From: [REDACTED]
To: [A303 Stonehenge](#)
Cc: [A303Stonehenge](#)
Subject: A303 Stonehenge PRow - Is a bridleway missing from the Draft DCO and associated access plans
Date: 27 August 2019 11:11:40

To the Planning Inspectorate, A303 Stonehenge

I would like to add my concern to that of Roger Upfold (Upfold 20018352 – see copy email below), on behalf of the British Horse Society (BHS), over the important section of apparently missing bridleway on the draft DCO.

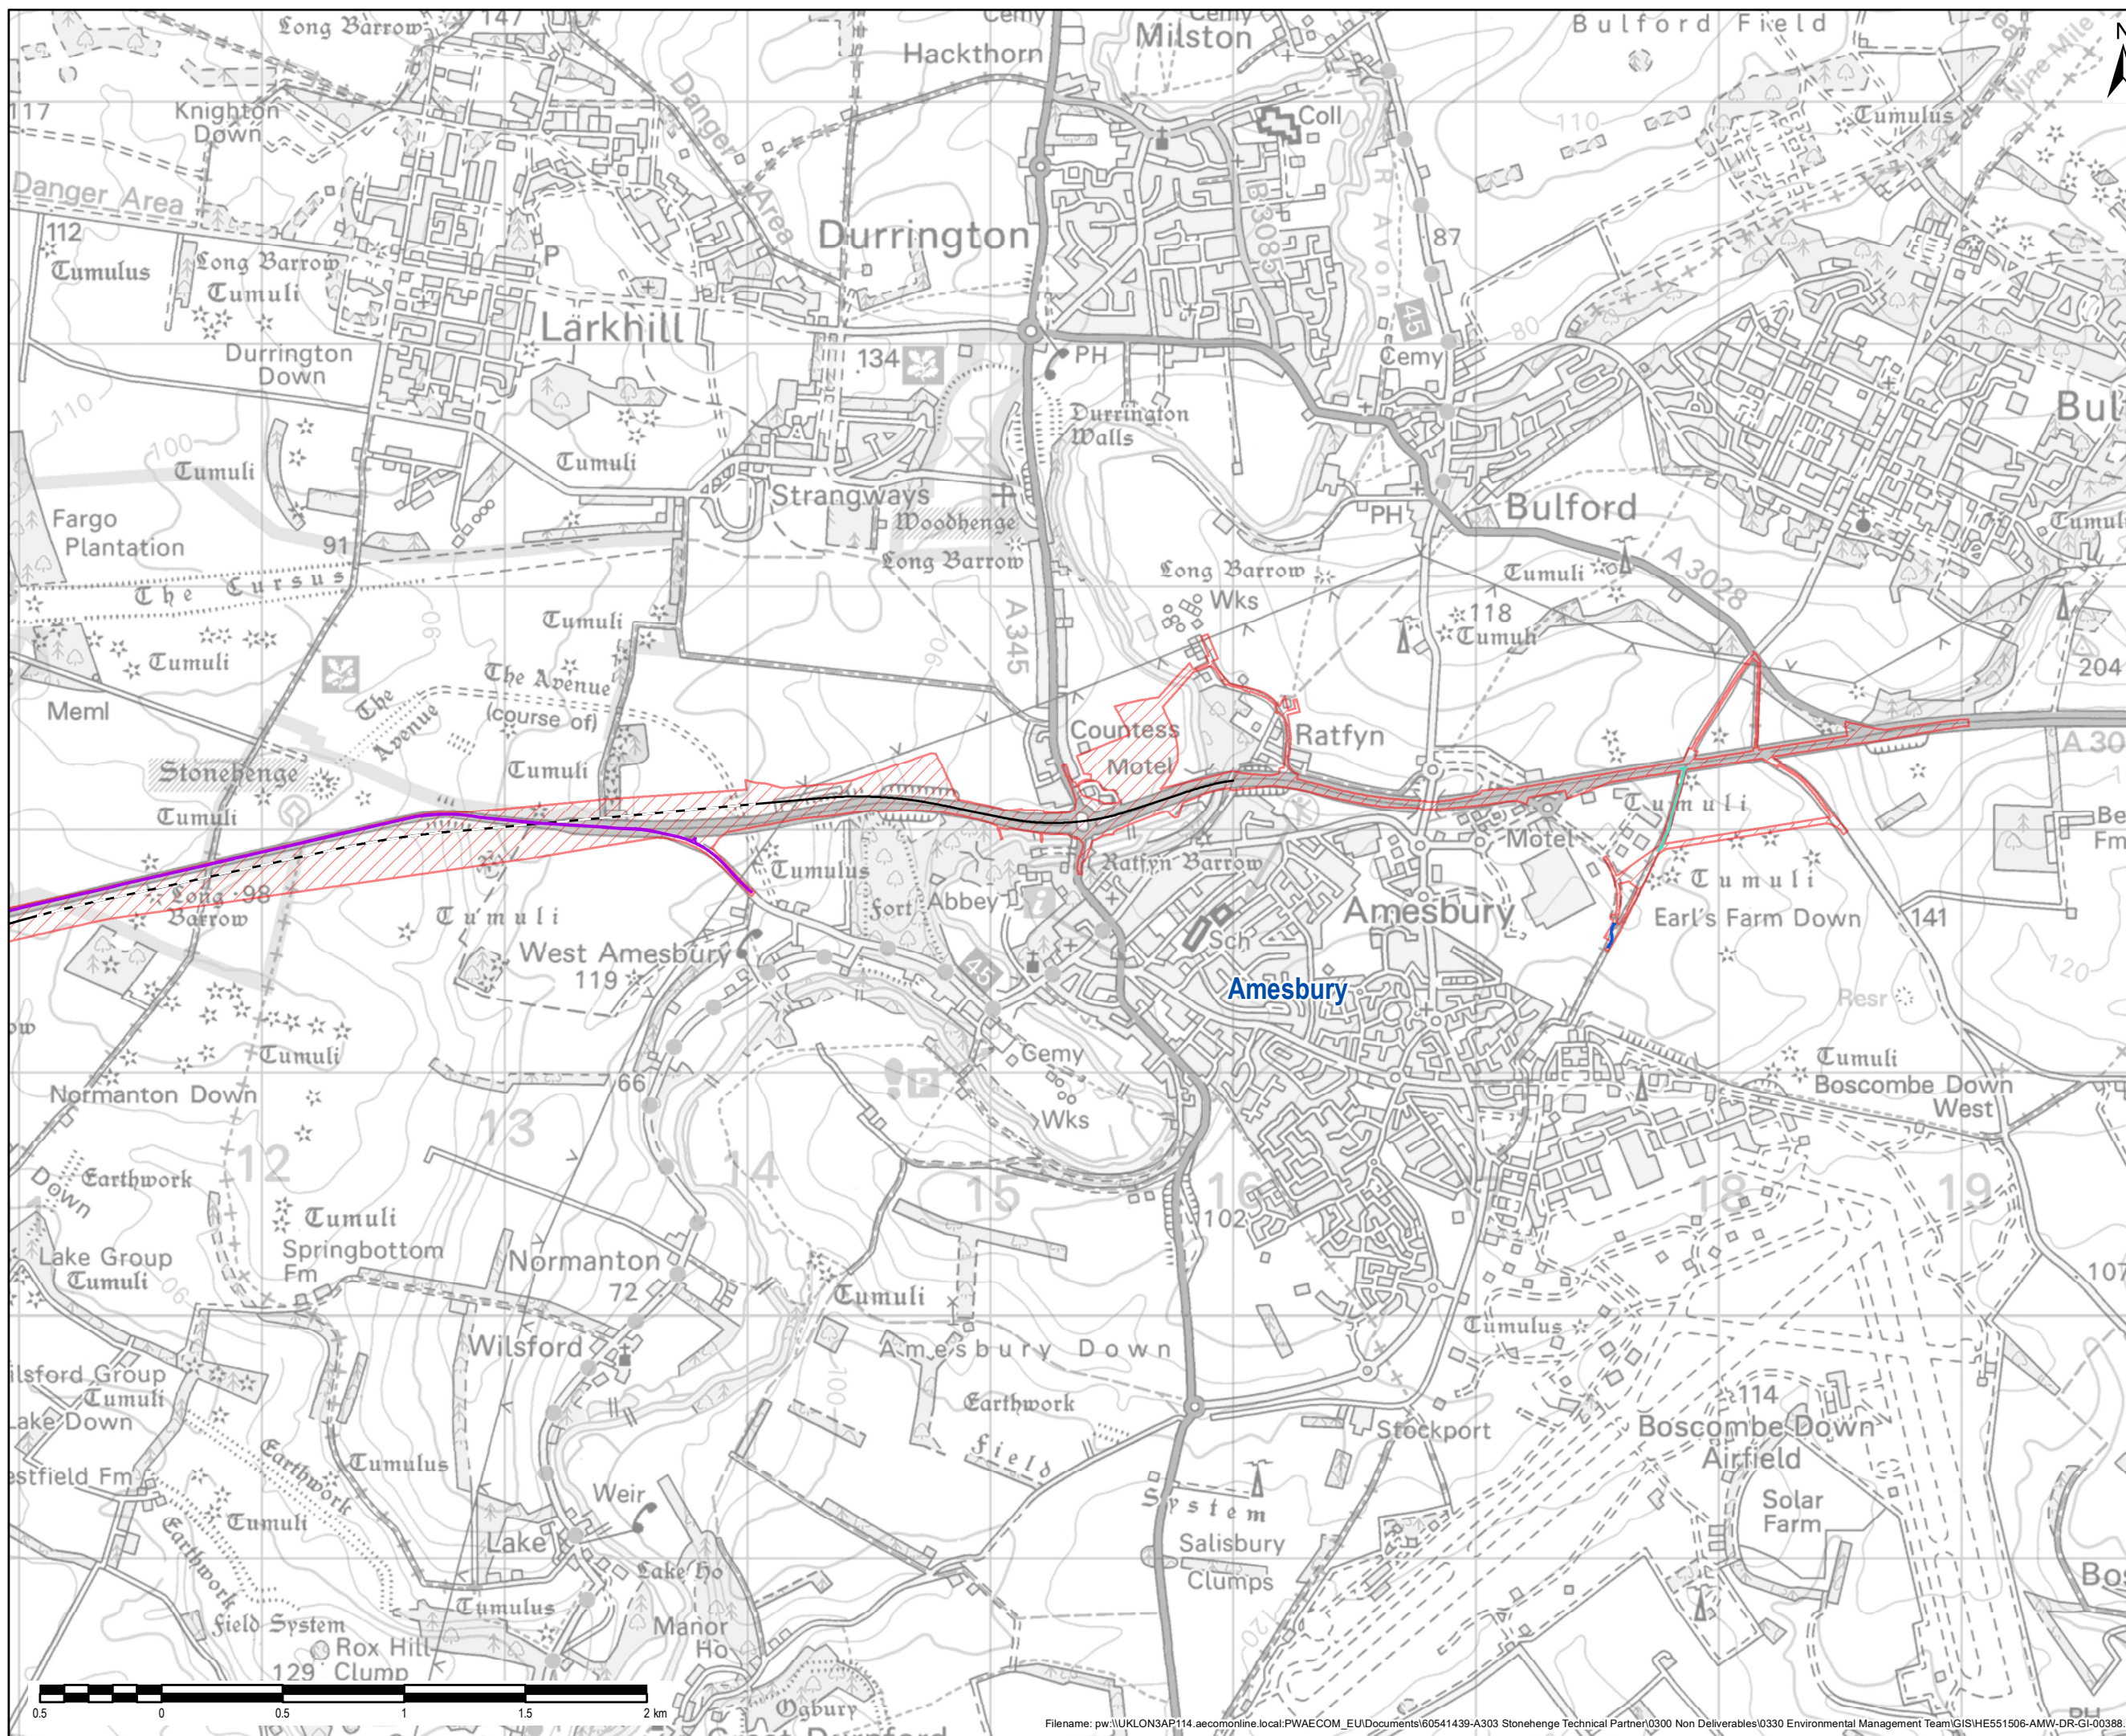
d) a new bridleway, east from Winterbourne Stoke to the new Longbarrow Junction, connecting with the new restricted byway through the WHS via the new green bridge to the east of the existing Longbarrow roundabout. The new bridleway and the new NMU route through the WHS would enable NMU journeys between Winterbourne Stoke and Amesbury;"

which is shown in green in Figure 13.3A of proposed NUM routes (document TR010025-000334-6-2_ES-Figure_13.3_ProposedNMUs.pdf).
